KITTTITAS COUNTY COMMUNITY DEVELOPMENT SERVICES

RE: Suncadia Ph. 3 Div. 15 & 16 Boundary Line Adjustment (BL-19-00004)

Community Development Services (CDS) received your application for the Suncadia Ph. 3 Div. 15 & 16 Boundary Line Adjustment (BL-19-00004) on March 1, 2019. CDS has reviewed your submitted materials and has determined that the application submittal packet is not complete. Consequently, this letter is intended to specify and outline what is necessary for a complete application.

JOB NO. 998-765-017-0002
DRAWN: C.A.F./R.F.G.
DATE: 2019-03-26
SHEET 1 OF 17

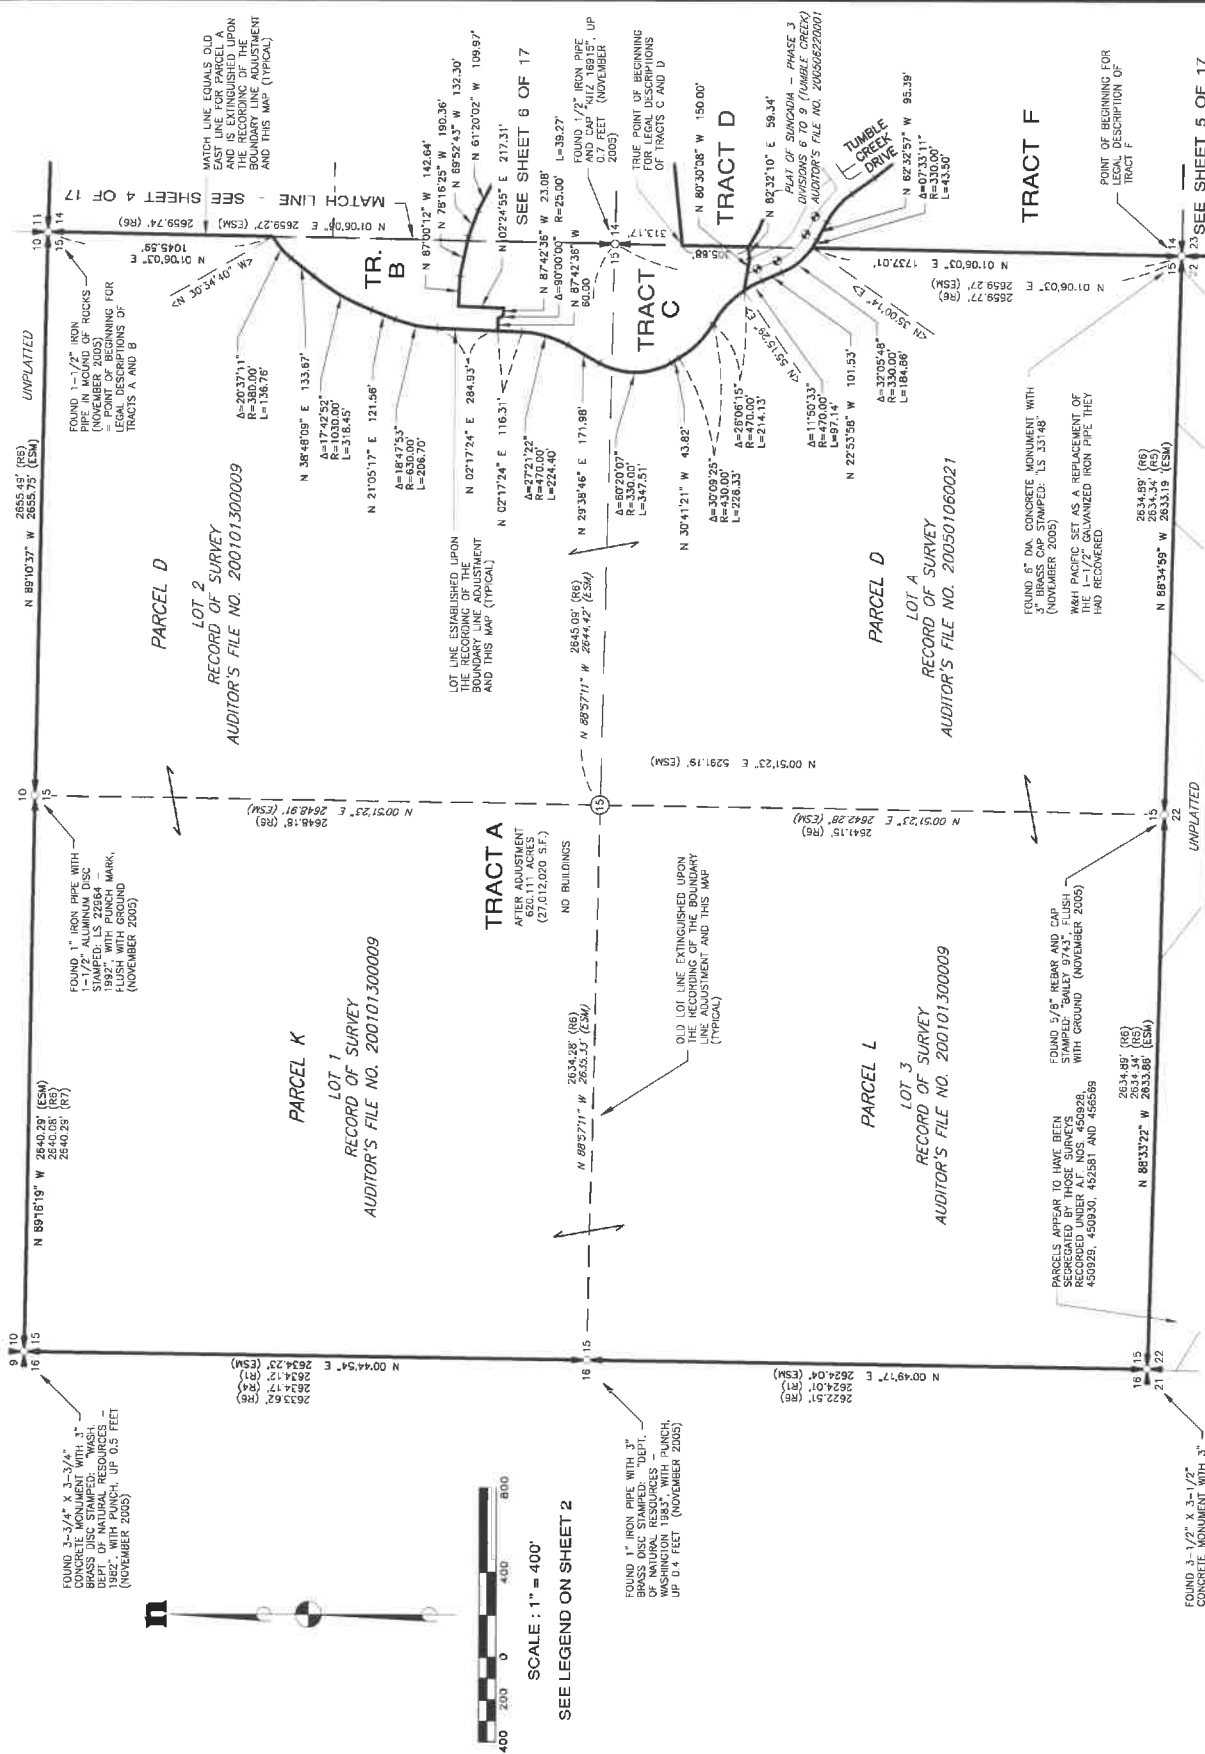
1. Narrative describing the project and how it relates to the approved development agreement for Suncadia.
2. Item 8 of the application requires the new acreage for the proposed tracts.
3. Sheet 1 of the preliminary survey must clearly show existing parcel boundaries.
 - a. Parcels H, J
4. Sheet 1 of the Preliminary survey has multiple parcels that appear to be identified with the incorrect parcel and map numbers.
 - a. Parcels H, I, J
 - b. Provided attachments to the boundary line adjustment application also include conflicting parcel and map number information for parcels H, I, and J.
